**KIRKLEES METROPOLITAN COUNCIL  
INVESTMENT & REGENERATION SERVICE**

**DELEGATED DECISION FOR APPLICATION FOR CERTIFICATE OF  
LAWFUL DEVELOPMENT**

Reference no.: 2021/CL/91230/E

Site: 517, Bradford Road, Birkenshaw, BD11 2AA

PROPOSED GROUND FLOOR PLAN
SCALE 1:50

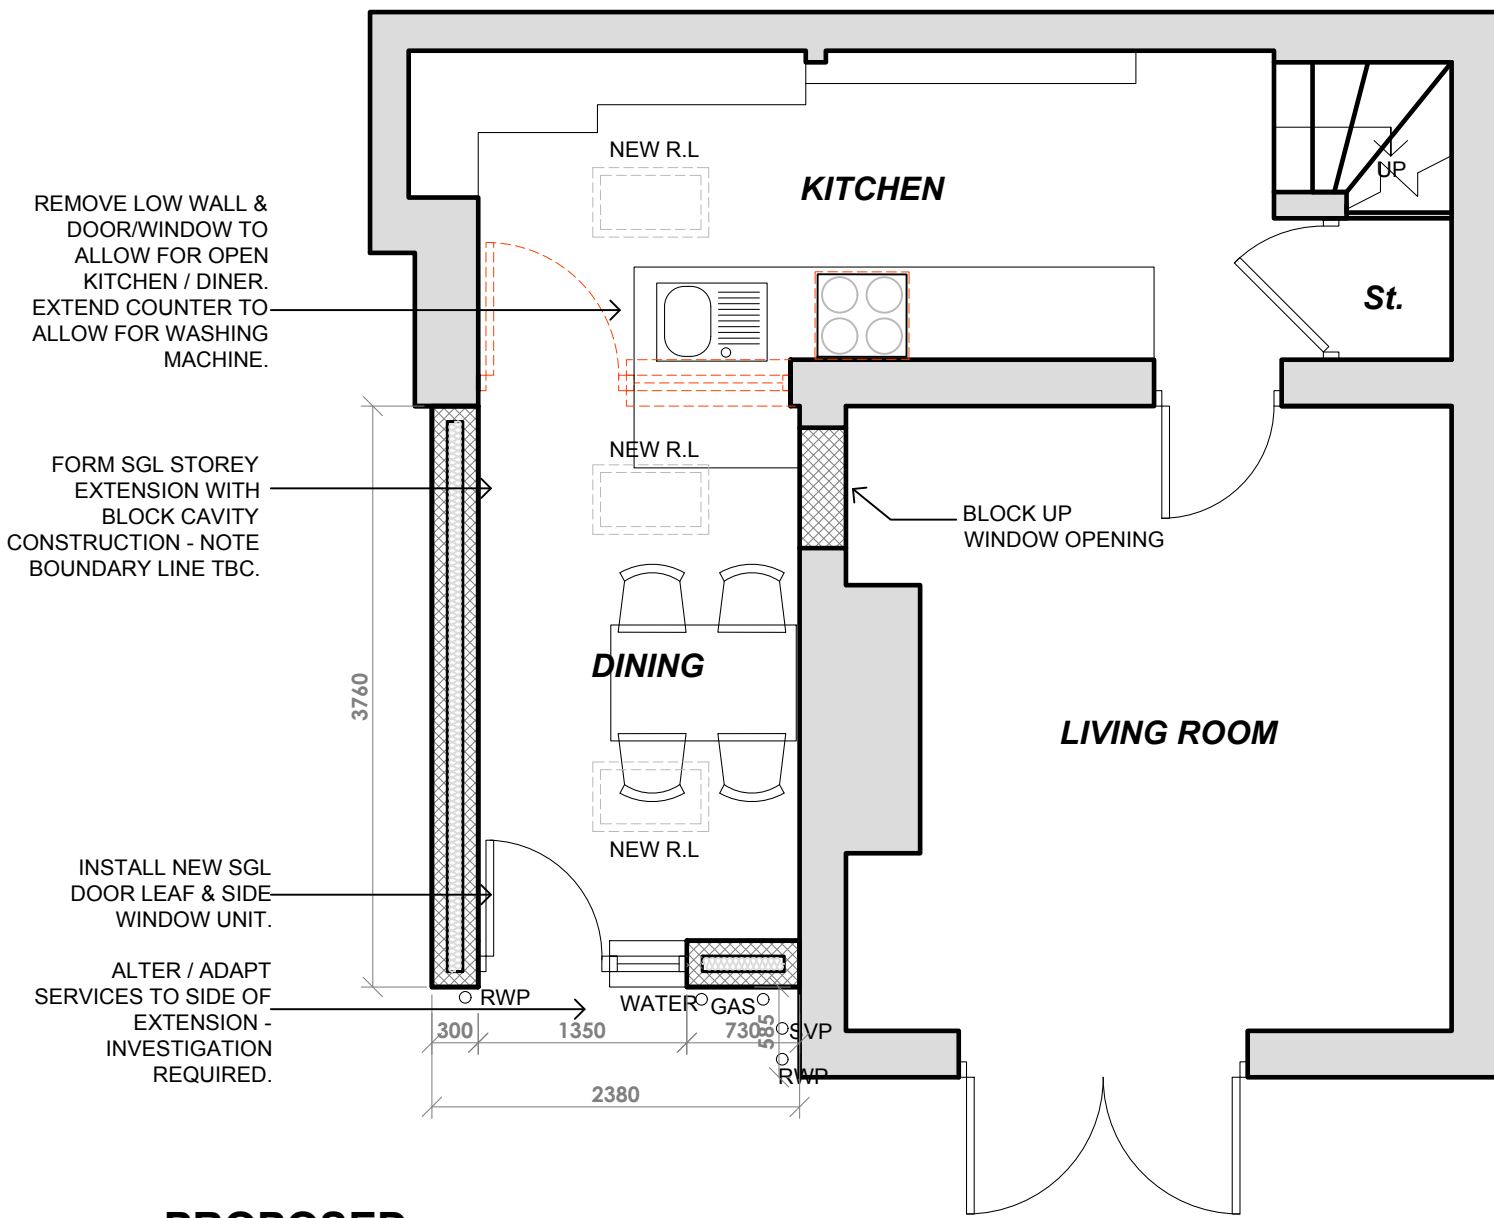
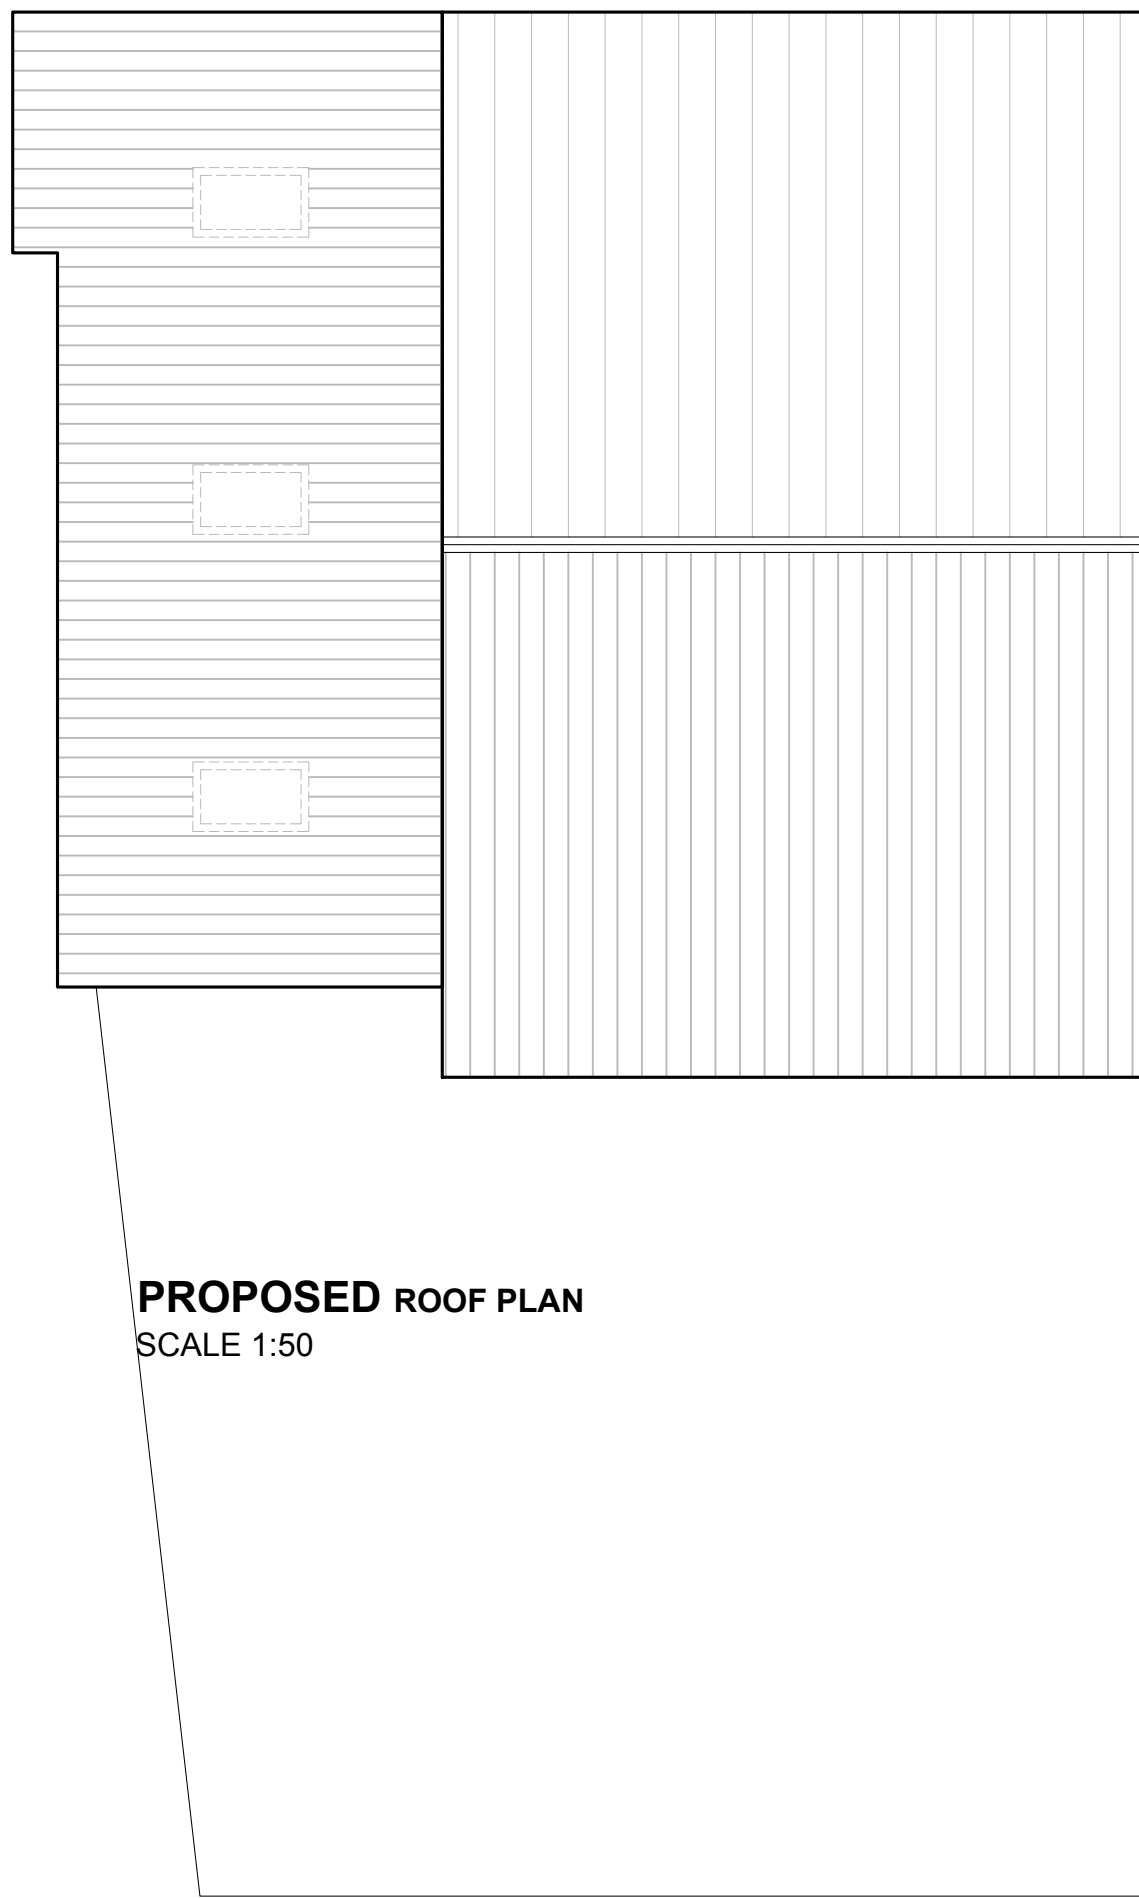
*Comment* The property has a width of 4.6m. As the side extension would project no more than 2.3m, the proposal falls within this criteria.

- (ja)** any total enlargement (being the enlarged part together with any existing enlargement of the original dwellinghouse to which it will be joined) exceeds or would exceed the limits set out in subparagraphs (e) to (j); *There is an existing single storey extension, whilst the proposed extension would not exceed the limitations of (e) to (j) the existing extension to which the proposed enlargement will be adjoined has a width greater than half of the width of the original house at 2.8m. The combination of the existing and proposed enlargement exceeds the limitations of paragraph (ja) by reason of paragraph (j)*

The proposed single storey side extension at 517 Bradford Road does not meet the criteria of permitted development as set out in Schedule 2, Part 1, Class A of the Town and Country Planning (General Permitted Development)(England) Order 2015 (as amended) as the proposed extension would join onto an existing extension which exceeds half of the width of the original house .
